City of Portland, Maine - Building or Use Permit Application

Permit No: 02-0952	Issue Date: SEP 11 2002	CEB#: 336 L030001
-----------------------	----------------------------	----------------------

Location of Construction: 5 Hillcrest Cir	Owner Name: Gullbrand Carl E &	Owner Address: 5 Hillcrest Cir
Business Name: n/a	Contractor Name: Mark Hawthorne Mawhinney	Contractor Address: 90 Pearl Street Apartment #1 South Po 2073294875
Lessee/Buyer's Name: n/a	Phone: n/a	Permit Type: Additions - Dwellings

Department: Building Status: Approved with Conditions Reviewer: Jeanine Bourke

THIS IS NOT A BOUNDARY SURVEY

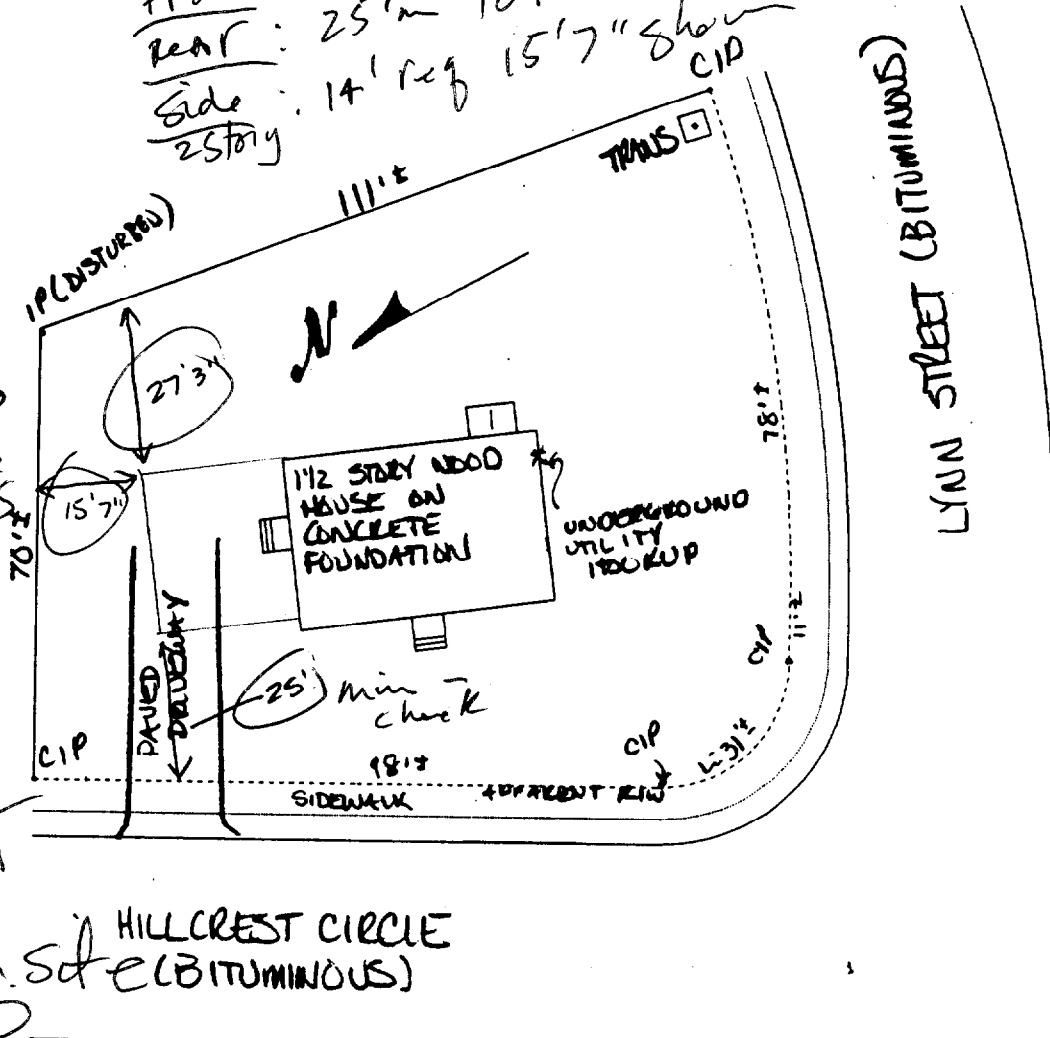
All setbacks are to be measured from PROPERTY LINES, not sidewalks or street lines. Our Code Enforcement Officers will be checking these setbacks prior to commencement of your work.

R-2
Front: 25' min to Front Property Line
Rear: 25' min to REAR Property Line
Side: 14' req 15'7" shown
2 story CIP

8/27/02 spoke with Mark M. in office about the setbacks to property lines NOT the side walks. - he HAS the pins & HAS string These measure ments already - I told him that the code enforcement officer would be measuring on side (BITUMINOUS)

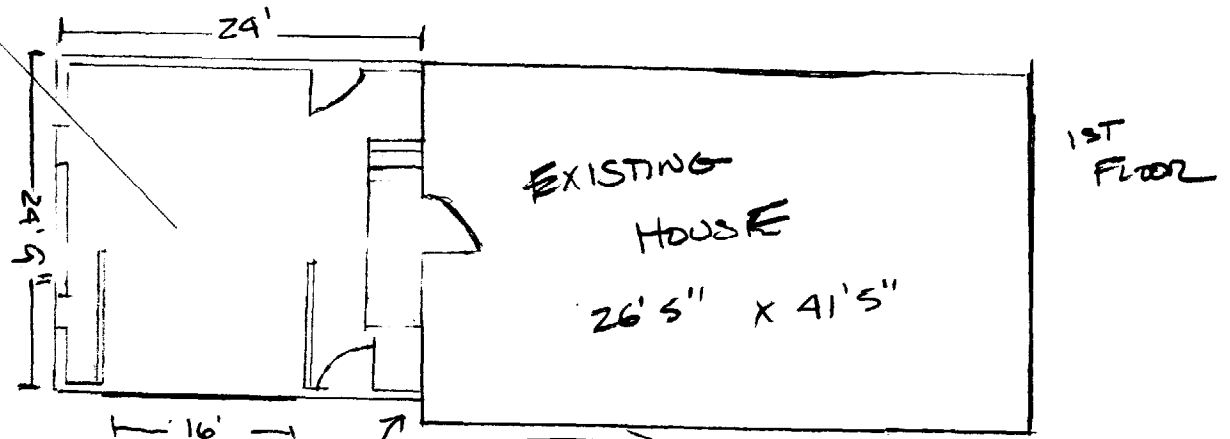
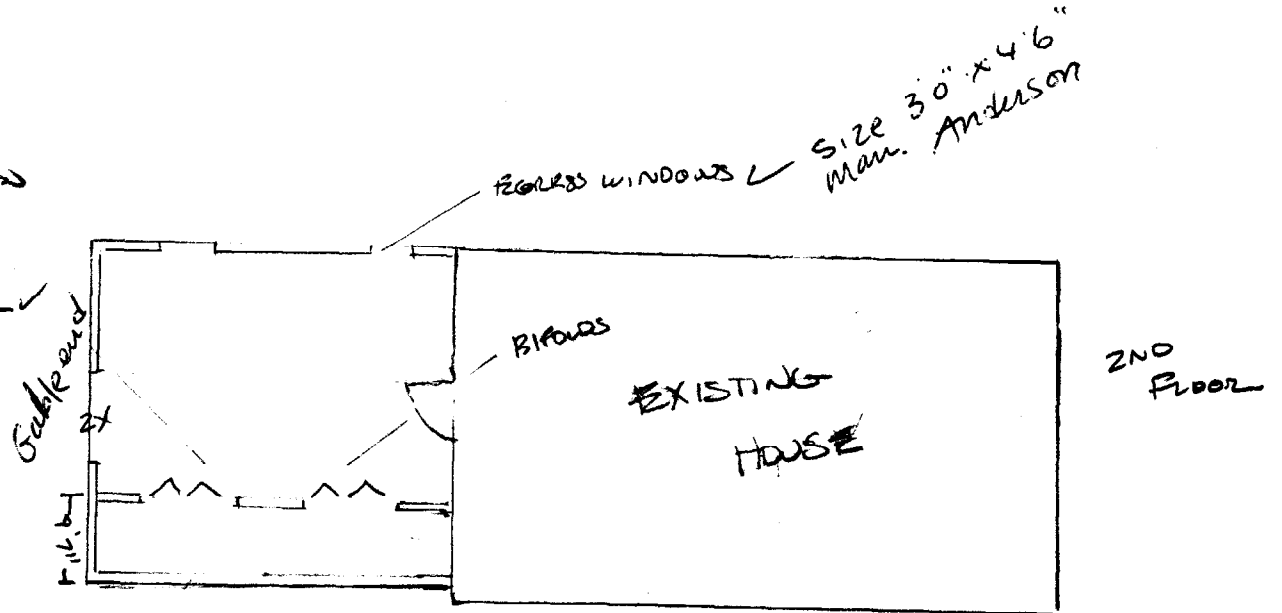
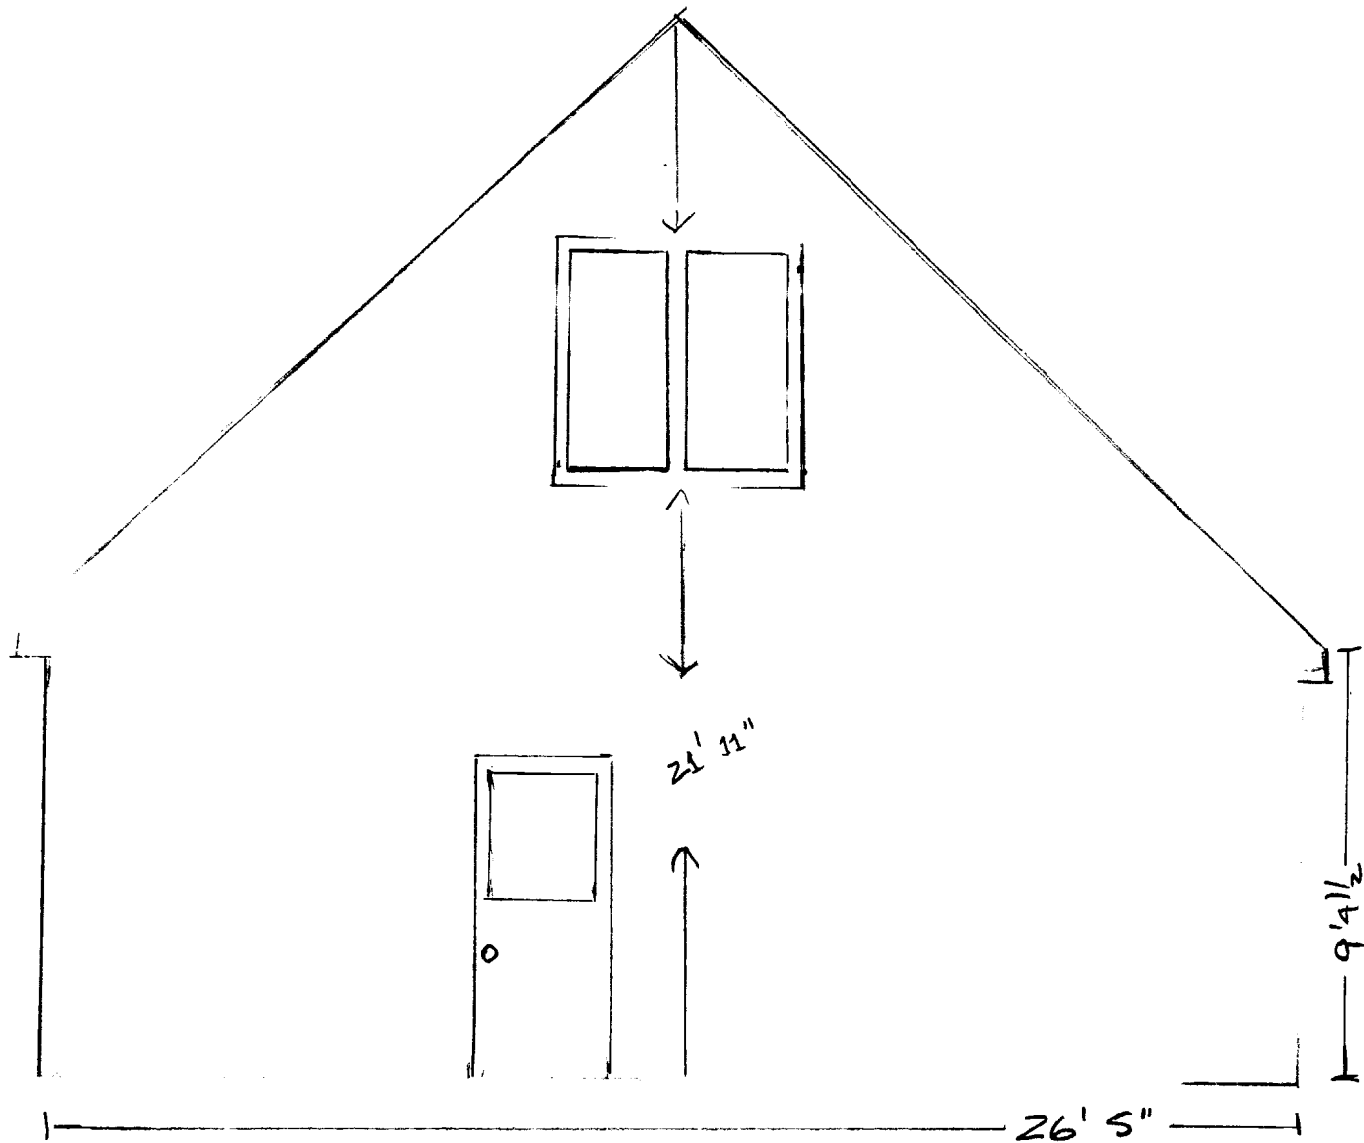
Steel beam specs shall be submitted prior to close in inspection

- ✓ 2 x 10 rafters
- ✓ 2 x 8 headers on all windows and doors
- ✗ 2 x 10 header on garage door *max span 8'6" NOT allowed*
- ✓ 5/8" firecode sheet rock on all garage walls and ceiling

W1430 STEEL BRAM NEED SPEC

- 8" x 16" footing 48" below grade
- 8" concrete walls pinned to existing foundation
- 4" slab
- all framing 16" o.c.
- 2 x 6 pressure treated ledger for framing
- 2 x 6 exterior wall construction
- 2 x 10 2nd floor joists 14' long supported by a center beam
- W1430 center beam supported by solid and continuous 2 x 8 posts to floor/foundation. Beam to span 23'6" and is centered on 24'9" wall.
- Engineers papers will be filed before inspection of flooring.

3-1 3/4" *

Tripled Boise Cascade Verso Lam
